Your Ref: OWPC20653
Our Ref: R/236/18/HH 04-10-2018
Please ask for:
Zac Denton

Proposed car port, boundary wall to front and associated landscaping
57 North Lane Rustington

Thank you for your internet representation made on 20th November 2018 which has been recorded as '**an objection**' with the comments as follows:

Proposed Car Port Design

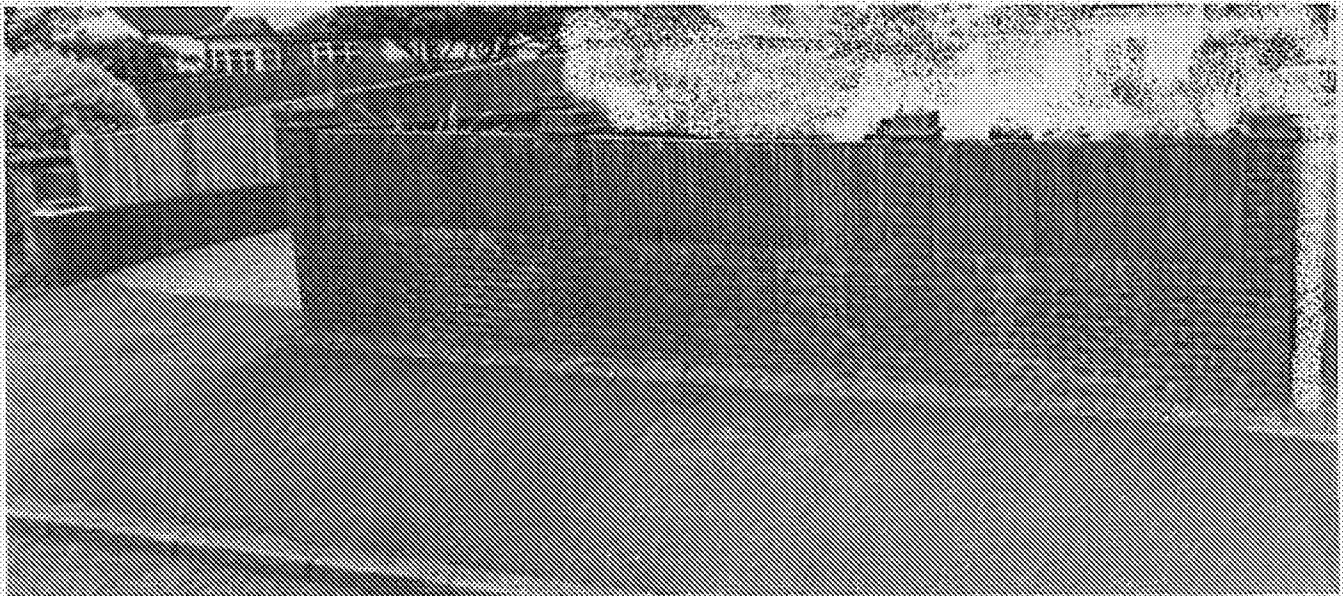
We wish to lodge a strong objection to the proposed plans for a car port and bin store on the grounds that it is far too big and far too high for a front garden and in our opinion too close to our boundary line.

Proposed Carport Boundary Wall to Front and Associated Landscaping

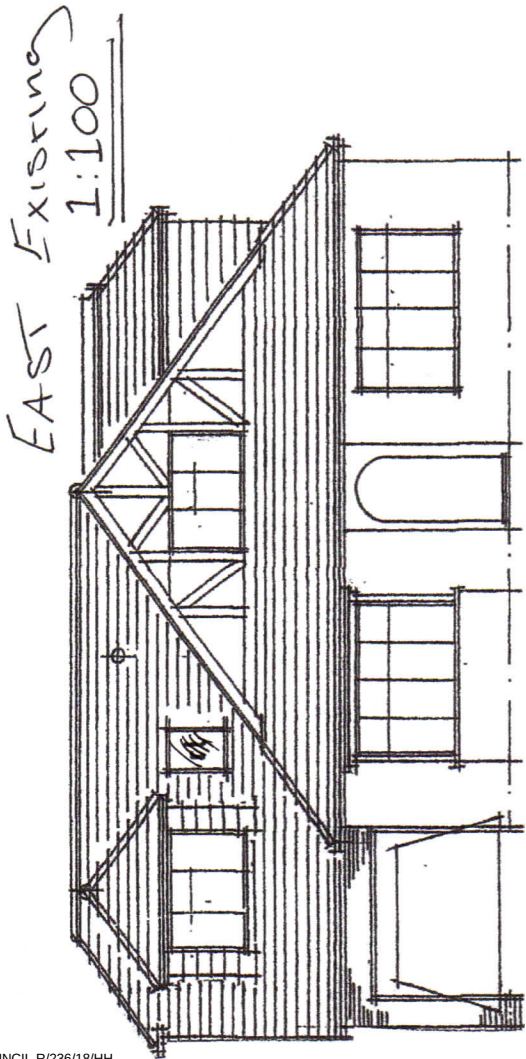
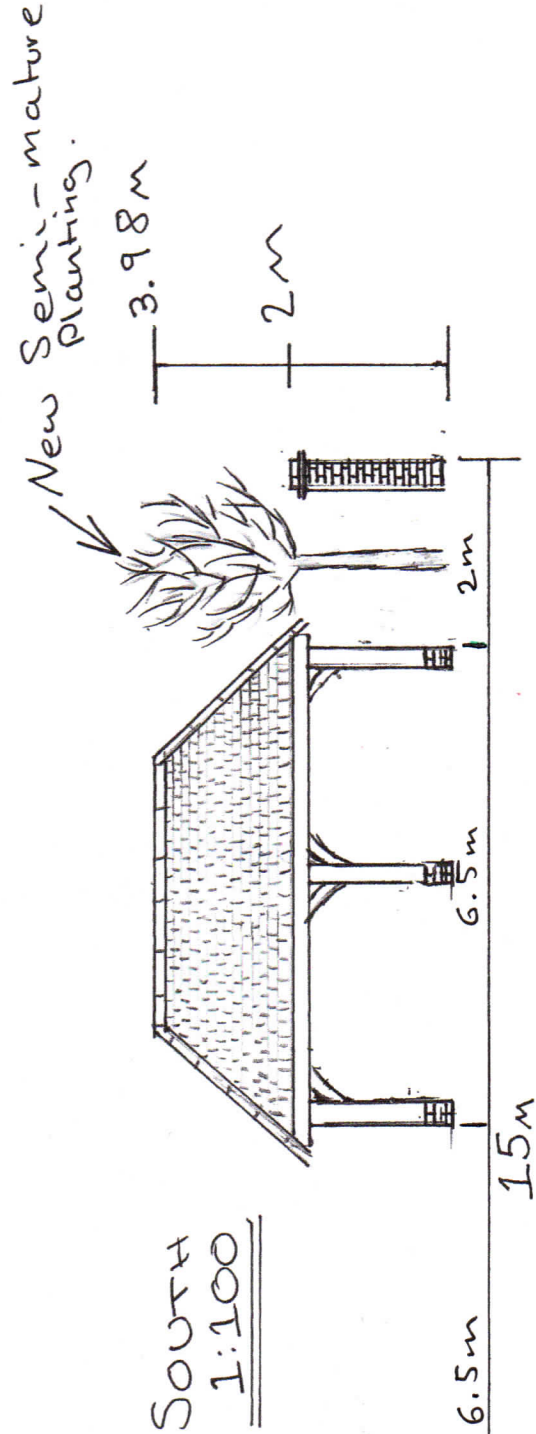
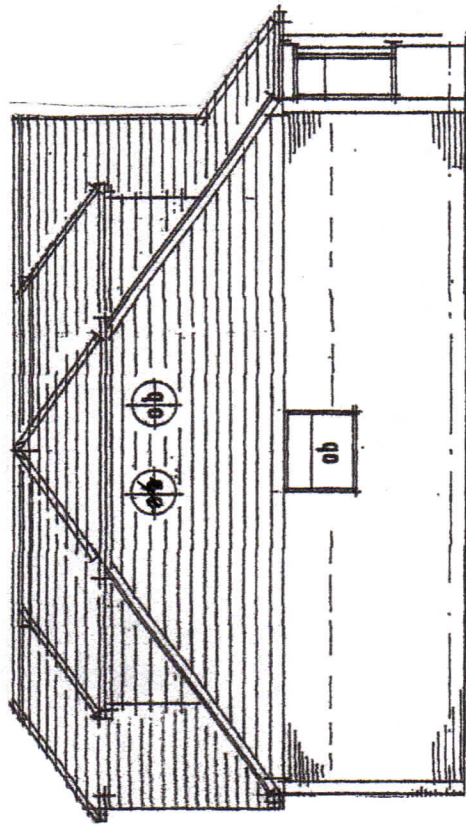
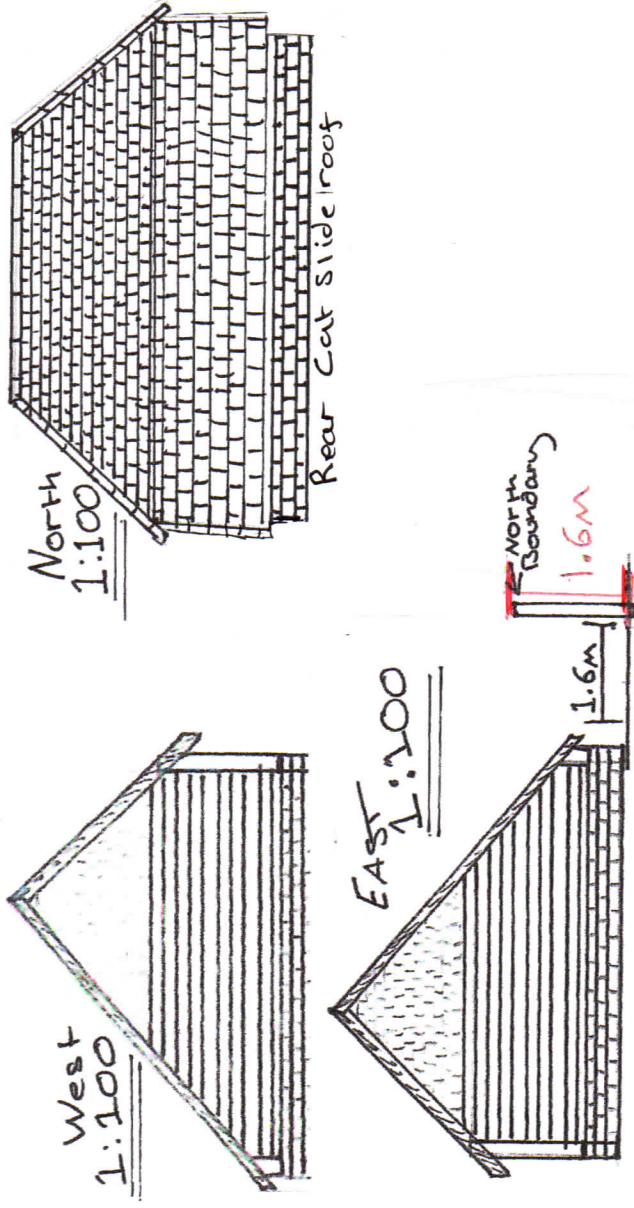
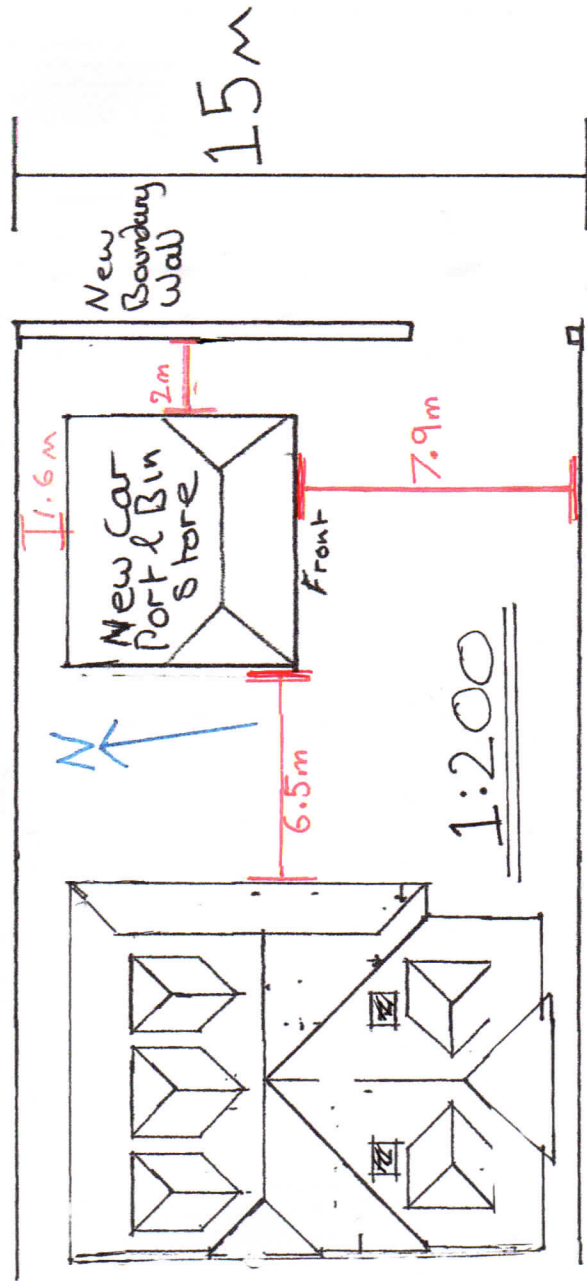
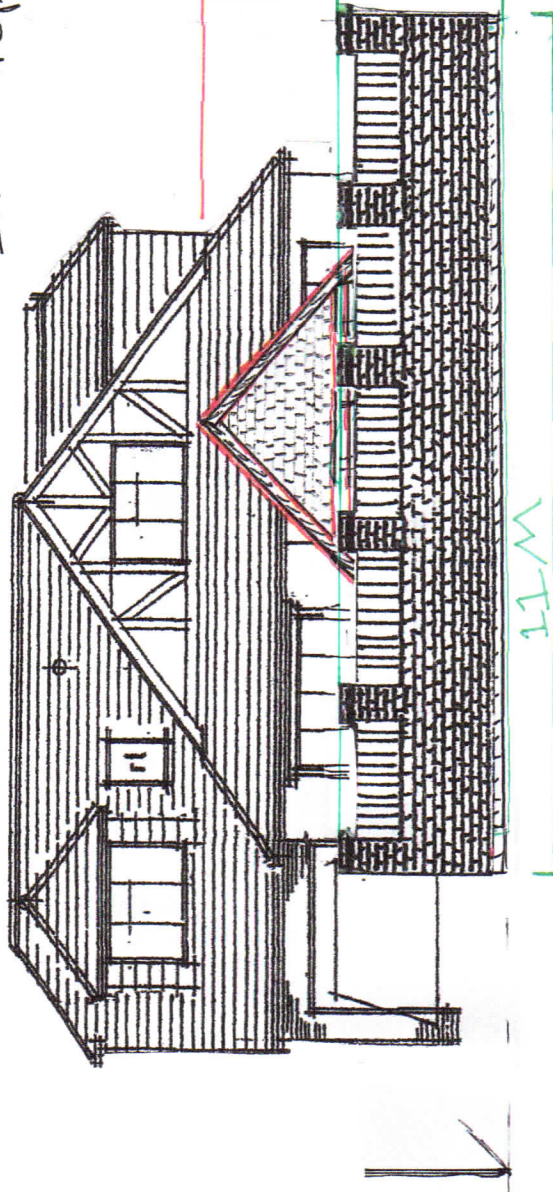
The scaled drawings provided make it hard to visualise the overall size, height and position of this construction in relation to the plot and neighbouring properties and the impact it will have on the overall street scene. No other construction of this magnitude has taken place in any other front garden in North Lane.

Please note that while the initial block plans show the houses along the road all with front gardens clear of buildings only in the revised B dimensioned drawings does it show the proposed car ports position and its distances from the property boundaries. If the block area of the proposed car port were on the initial block plan then the impact of the proposal to the overall street scene and neighbouring properties would be better displayed.
